From: Anita Gardner <Anita.Gardner@arun.gov.uk>
Sent: 25 August 2021 12:11
To: Planning.Responses <Planning.Responses@arun.gov.uk>
Subject: FW: F/7/21/PL

Subject: FW: F/7/21/PL

I'm just checking that you're not waiting for anything else from me or the client re: F/7/21/PL – 1.28 Ha High-Tech Glasshouse & Reservoir.
Don't hesitate to let me know if you need anything else.

Drawing Title
Proposed Lagoon

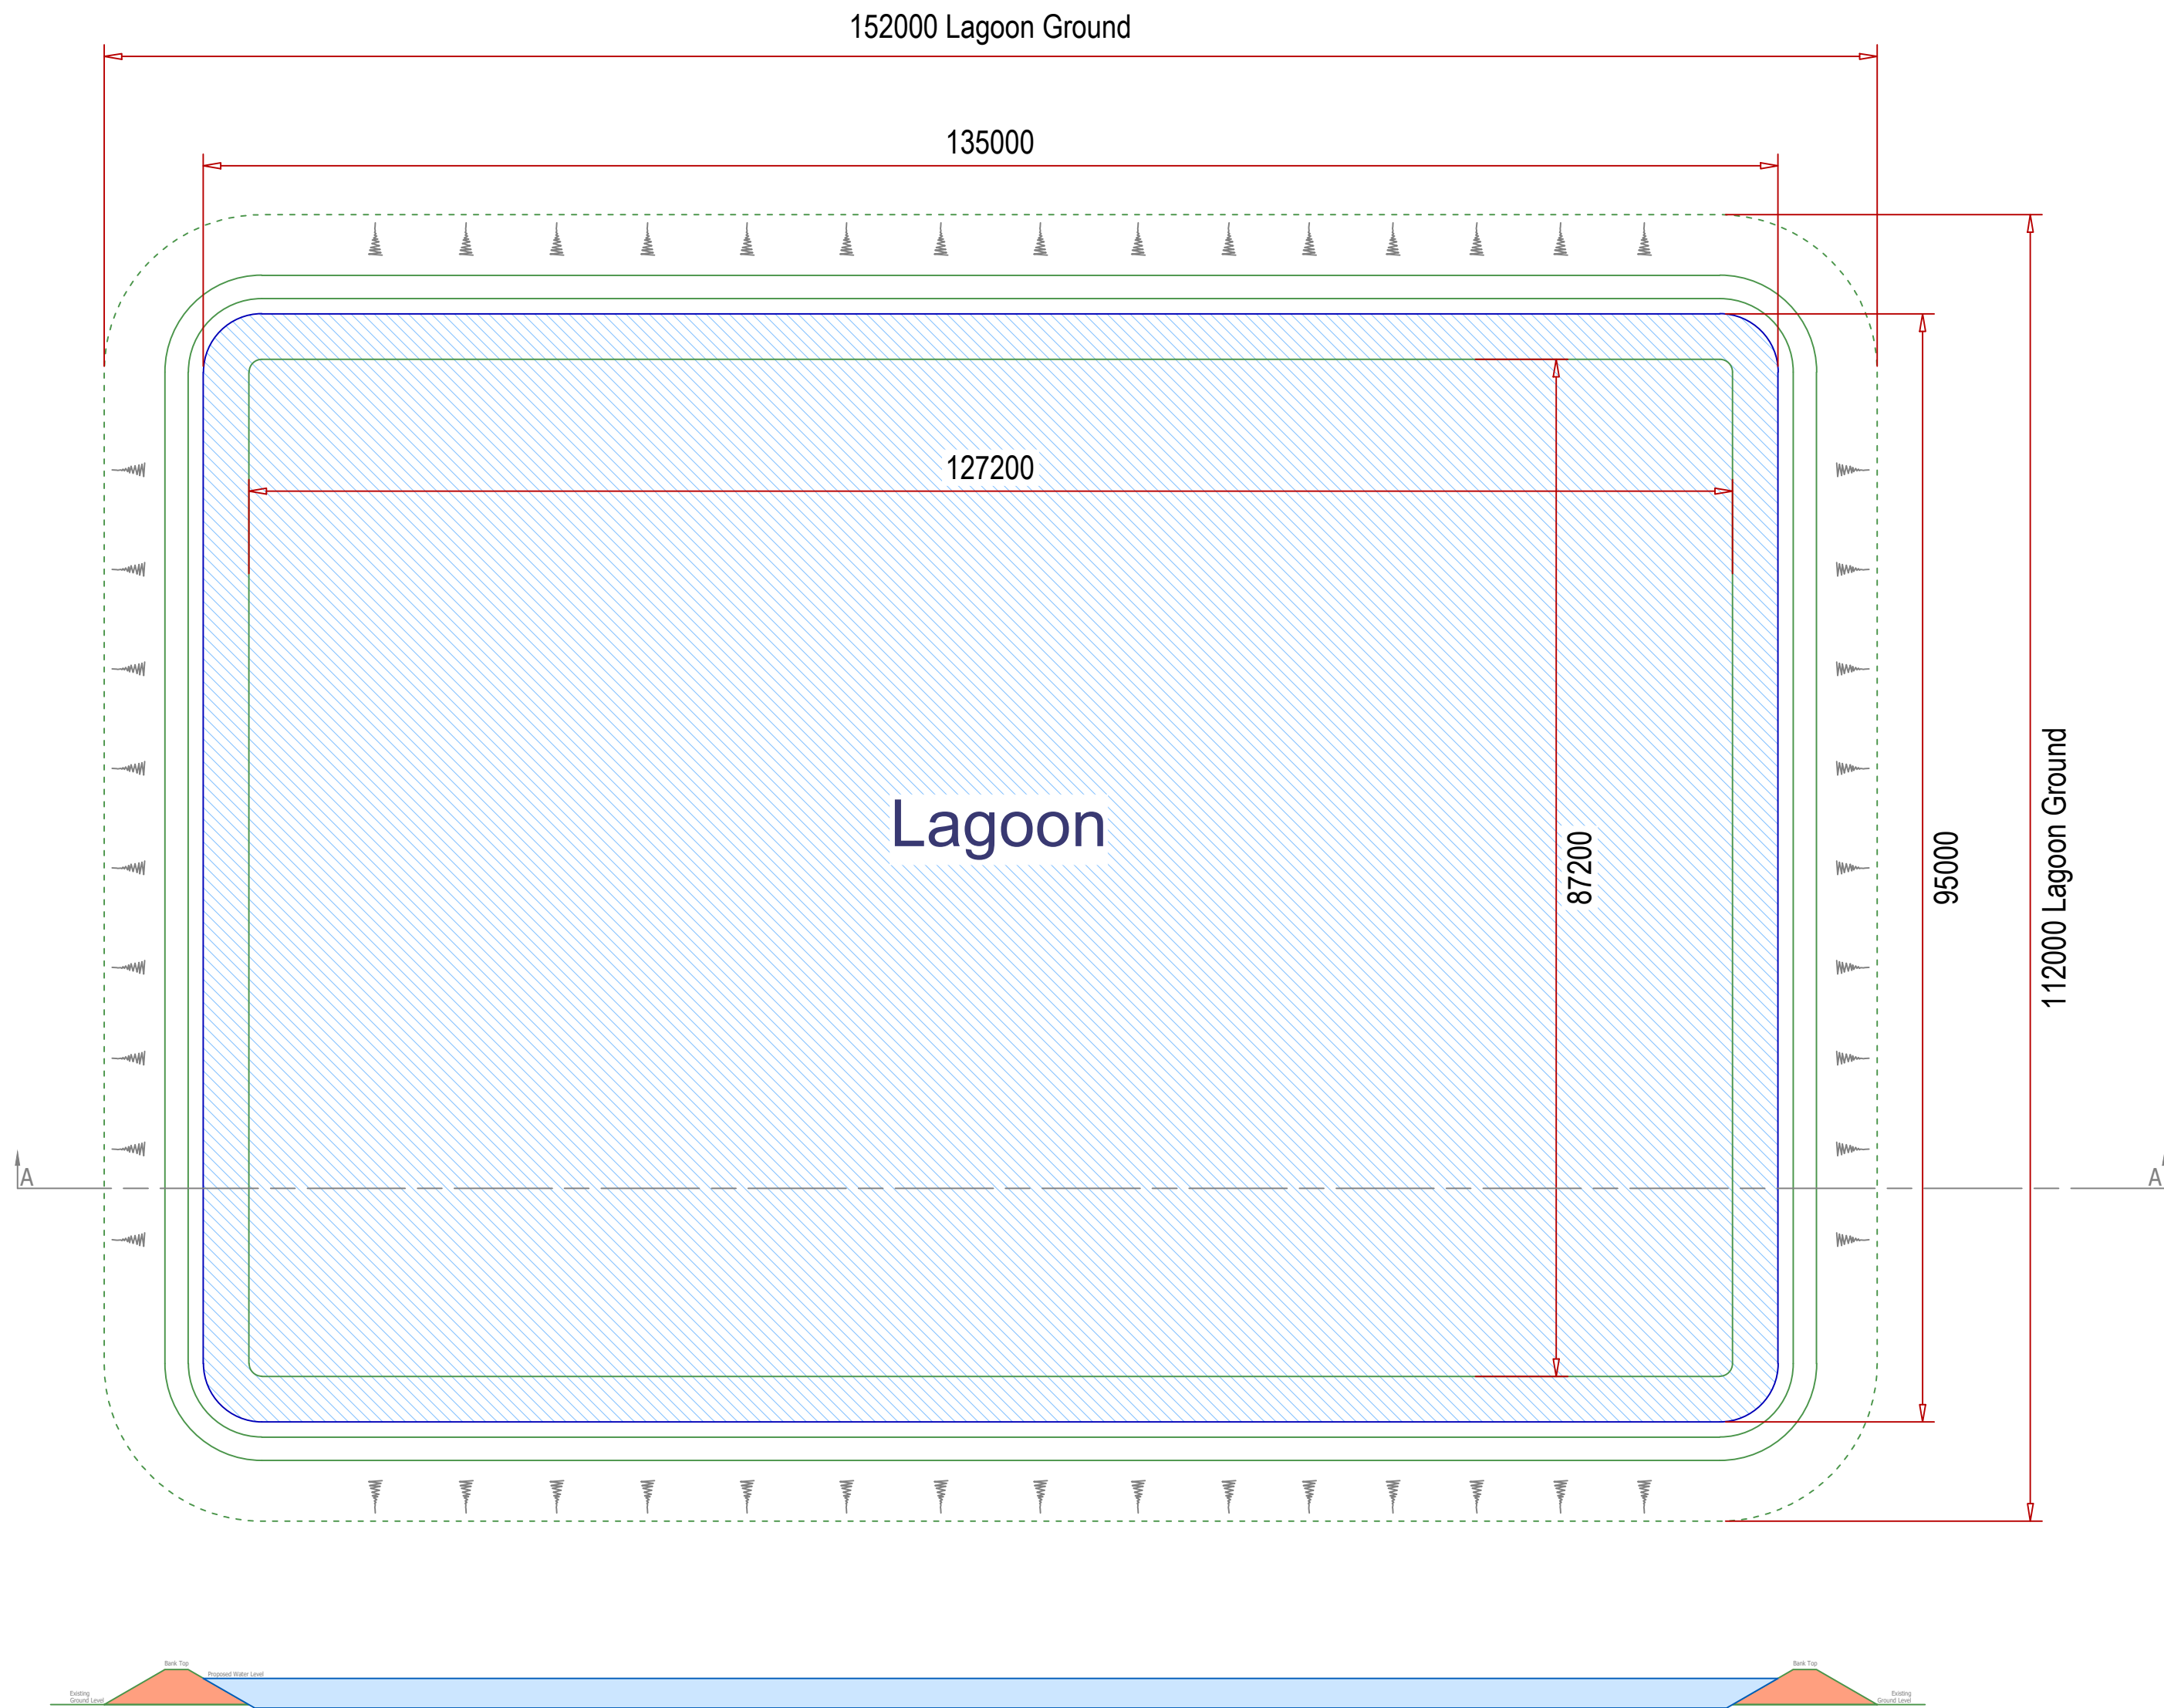
- There is no indication of the capacity of the reservoir in the submitted Flood Risk Assessment (FRA). Our initial calculations suggest that this would be classed as a Large Raised Reservoir. Subsequently, we would require further details of how this proposal would be planned, designed and constructed in accordance with the Reservoir Act requirements. This includes appointing an All Reservoir Panel Engineer as a construction engineer to oversee and supervise building the reservoir.

We have updated the details of the reservoir to clarify the proposals. We confirm the maximum retained water volume is less than the 25,000m³ which would be considered a Large Raised Reservoir. After a 100 years storm event +40% CC the Reservoir could holding a maximum of 22,970m³, the maximum retained water within the Reservoir for irrigation is 19,500m³. We attach an updated plan detailing the Reservoir dimensions. Based on the above an All Reservoir Panel Engineer as a construction engineer to oversee and supervise building the reservoir will not be required.

RESERVOIR SECTION
(Scale 1:100)

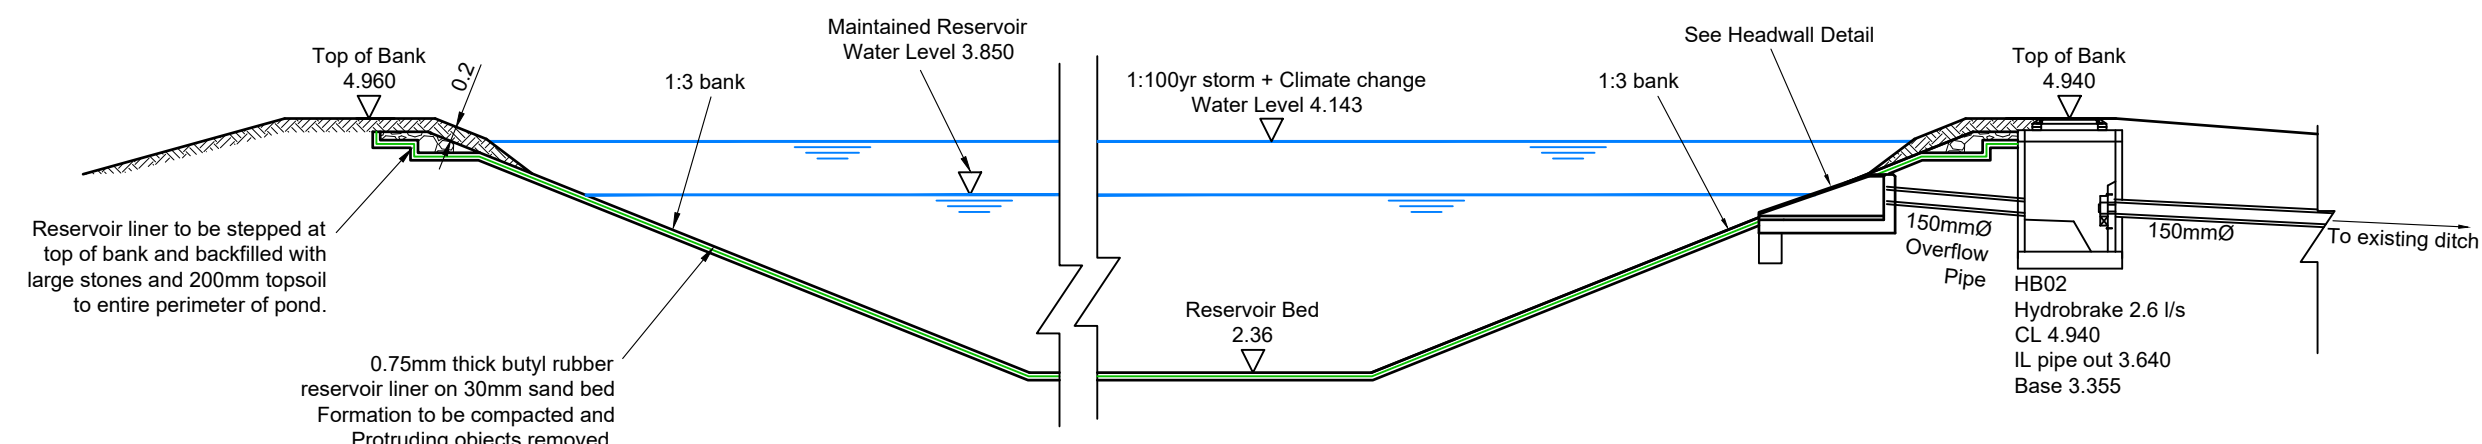
- The reservoir should be constructed in accordance with the Small embanked reservoirs CIRIA Guidance 161 (side slopes 1 in 3 and a crest width of 3 metres) and there should also be details of the overflow arrangement.

Proposed Reservoir dimensions and arrangement has been updated to include 1 in 3 banks and a crest width of 3m in accordance with Small embanked reservoirs CIRIA Guidance 161. The northern bank will be constructed with banks 300m lower than the eastern, western and southern banks to provide an over flow route towards the River and away from any buildings and development. It should also be noted that a 300mm free board allowance has been provided above the 1 in 100 year +40% cc storm level, providing over double the storage required above the retained water level.
